From: Mundy, Ben - Oxfordshire County Council <Ben.Mundy@Oxfordshire.gov.uk>
Sent: 16 January 2023 13:13
To: DC Support; Rebekah Morgan
Cc: Transport CDC Minor; Cllr Ian Corkin
Subject: 22/03756/F Wendlebury Park Farm, Wendlebury Road, Chesterton, Bicester, OX25 2PE

Planning Application: 22/03756/F

Location: Wendlebury Park Farm, Wendlebury Road, Chesterton, Bicester, OX25 2PE

Description: Additional building within existing yard area for associated B1 and B8 use.

DRAWING NUMBER:
5442 / 20C

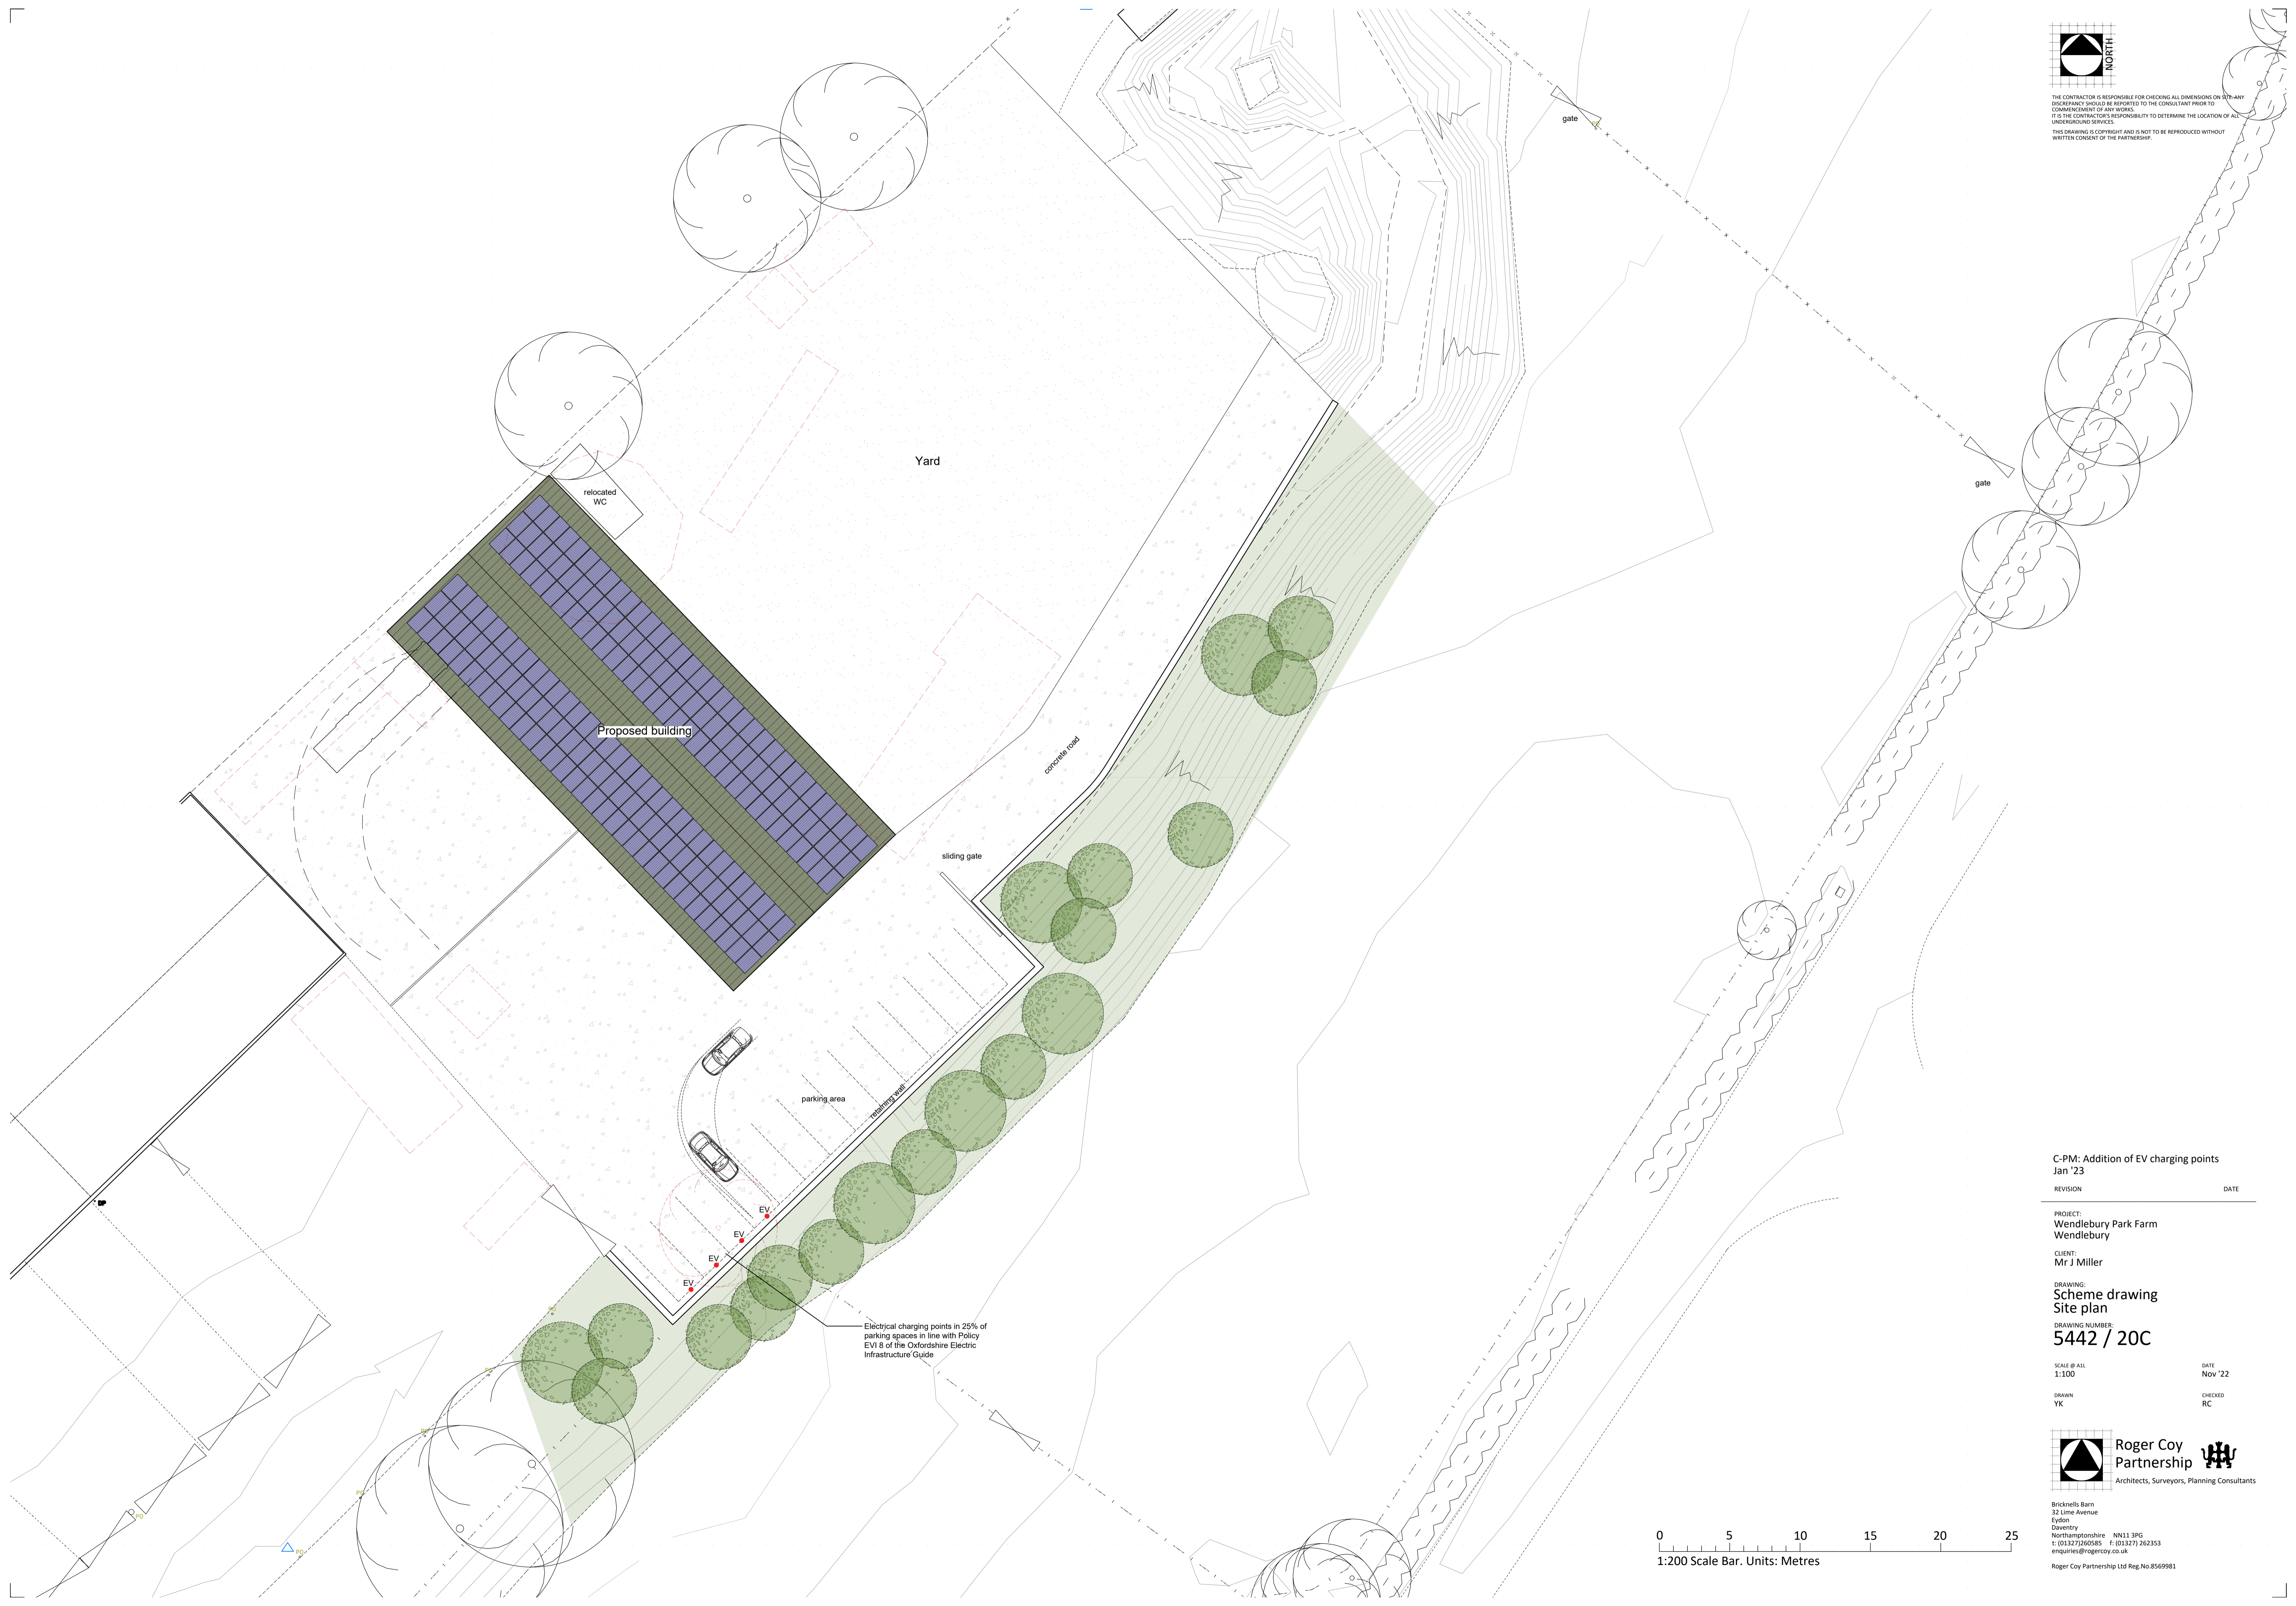
Prior to the first occupation of the development, a scheme for the provision of a vehicular electric charging point to serve the development shall be submitted to and approved in writing by the Local Planning Authority. The vehicular electric charging points shall be provided in accordance with the approved details prior to the first occupation of the unit they serve, and retained as such thereafter.

The dimensions and quantity of the vehicle parking proposed within this development is at an acceptable level when comparing it to the size and use of the development. However, all new parking areas must have E/V charging infrastructure, Policy EVI 8 of the Oxfordshire Electric Infrastructure Guide states that in areas with unallocated parking, EV charging infrastructure must be installed in 25% of the spaces, the plans will need to be revised to show this. The access point is existing and poses good visibility in both directions, meaning the intensification of use will not pose a significant safety concern.
